# ENG-CDR19004-R3-TS-CDs-Redlines .pdf Markup Summary

**Subject:** EPC ENG Review  
**Page Index:** 1  
**Date:** 8/19/2020 4:18:17 PM  
**Author:** dsdrice  
**Color:** ■  
**Layer:**  
**Space:**  
**Page Label:** 1

**MERIDIAN ROAD STREET
 IMPROVEMENT PLAN**

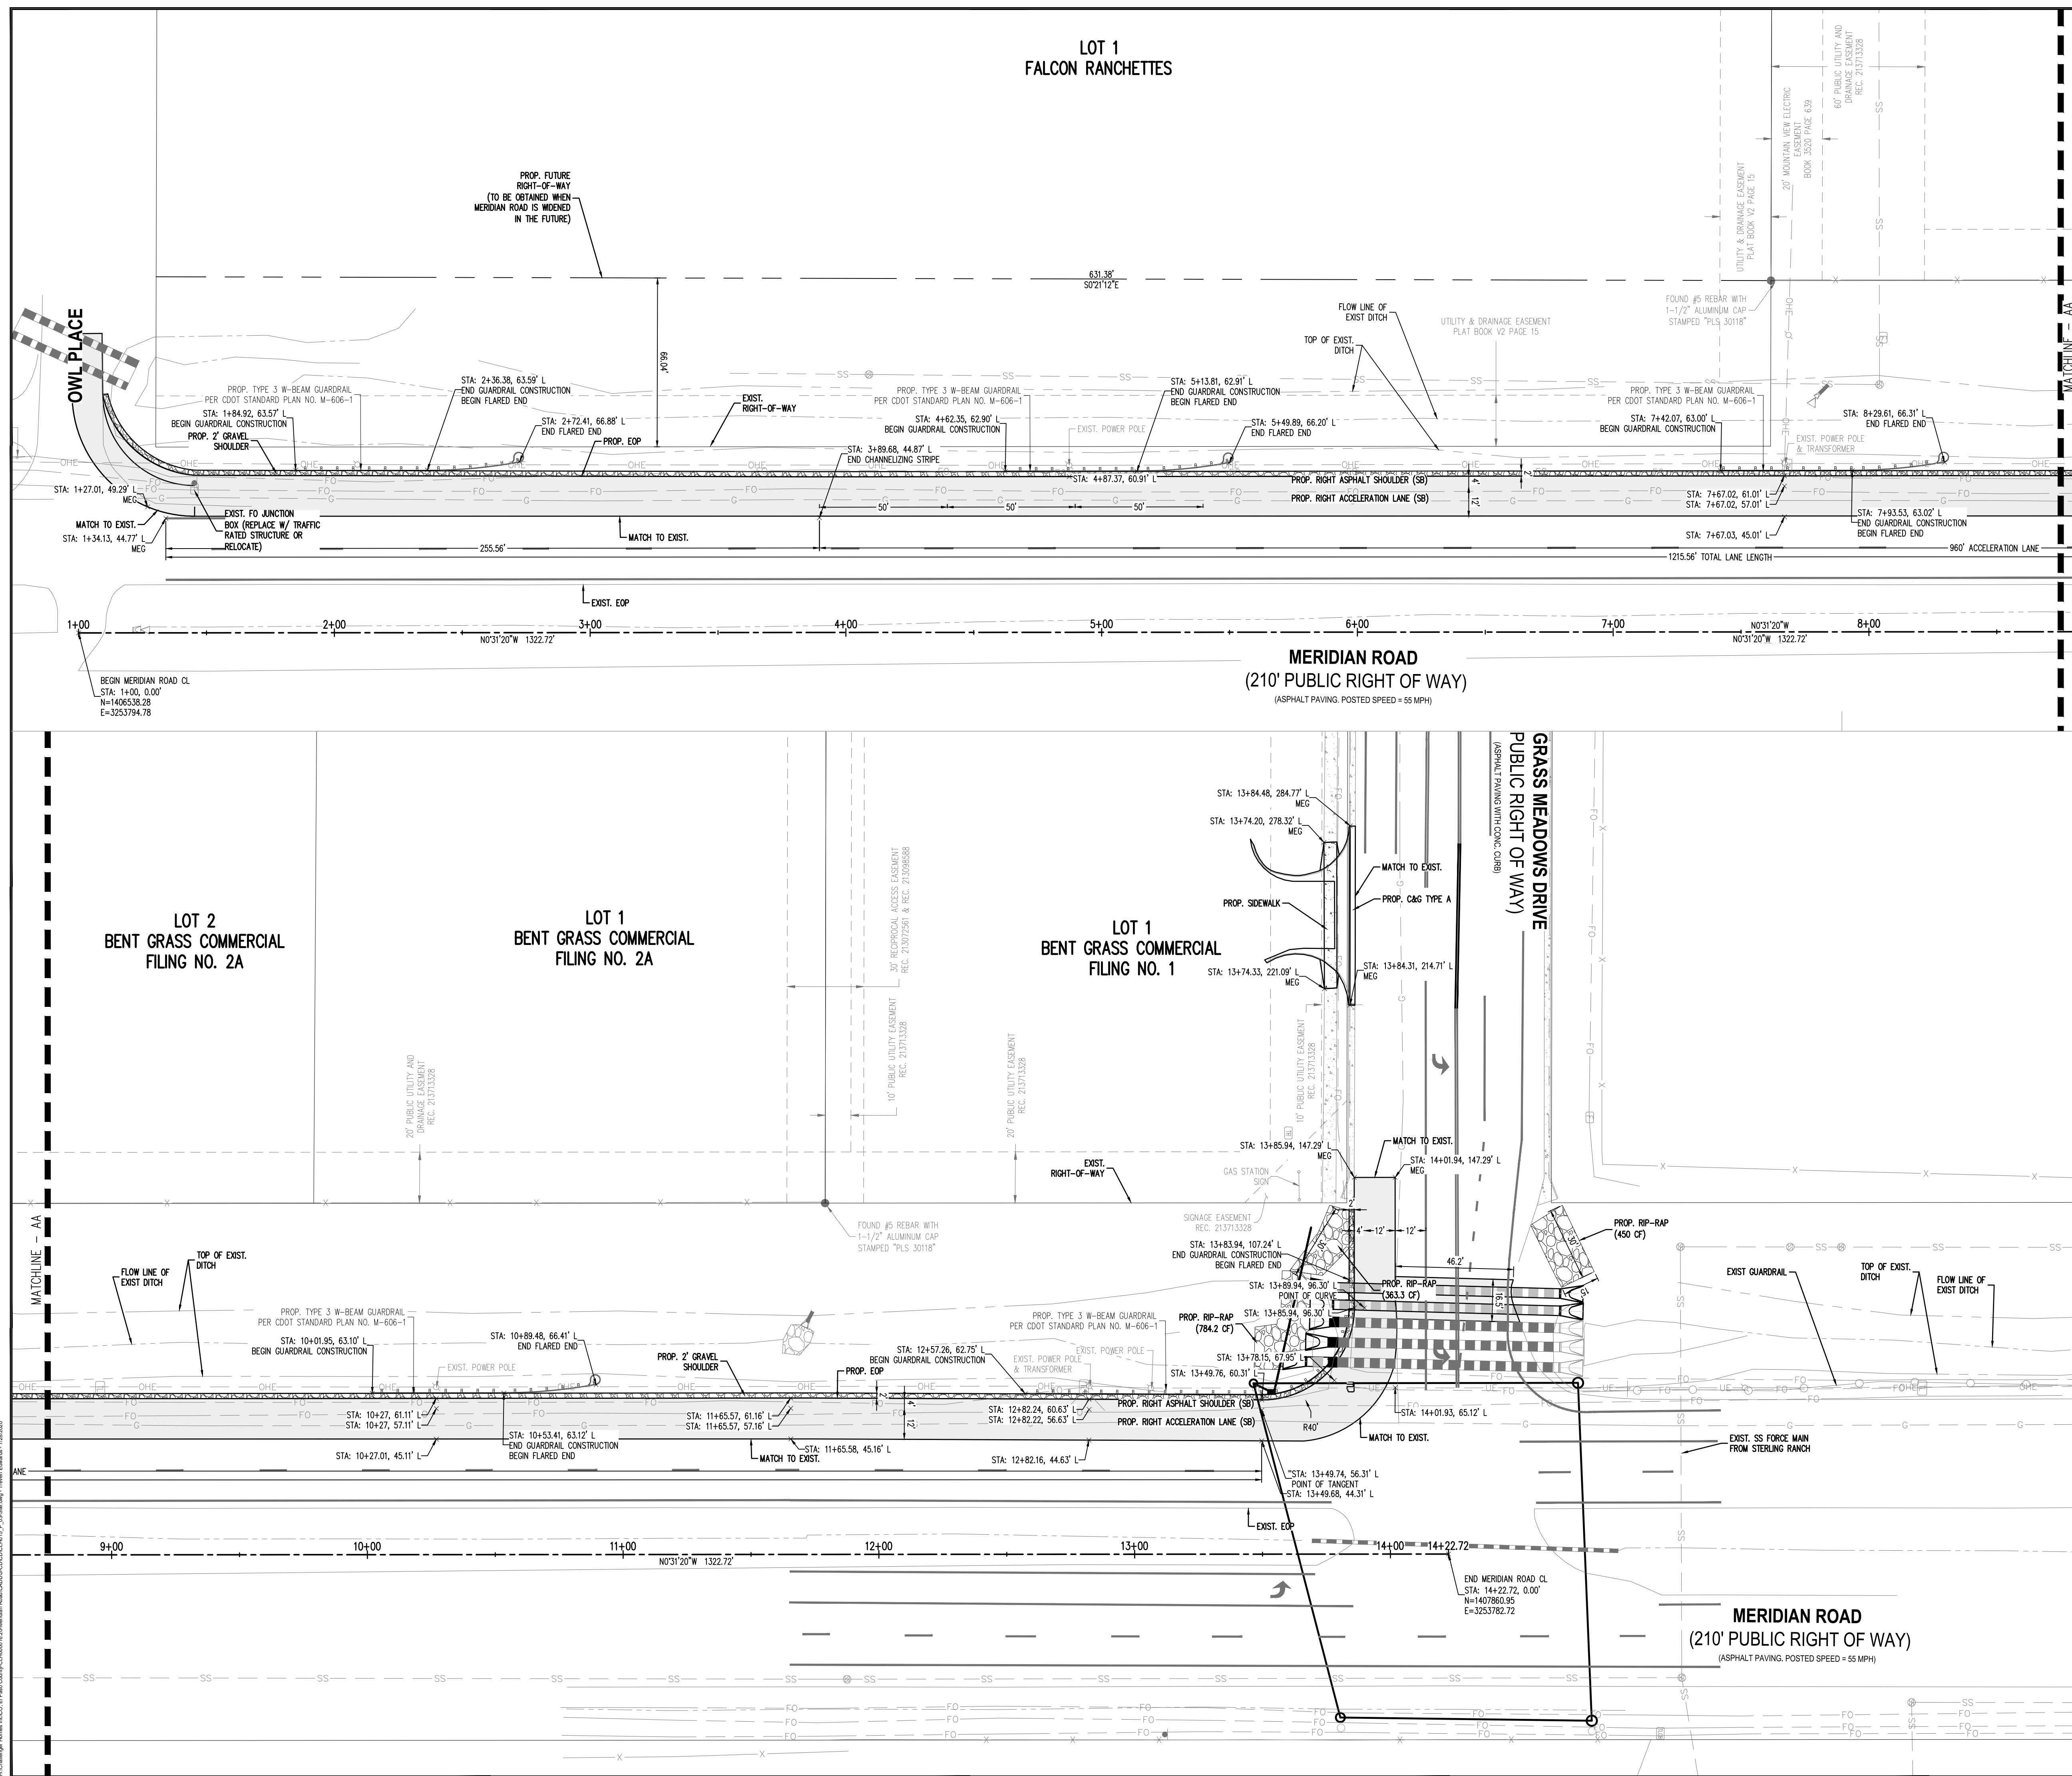
This appears to be in the future sidewalk/trail location. See Galloway exhibit.

no cameras
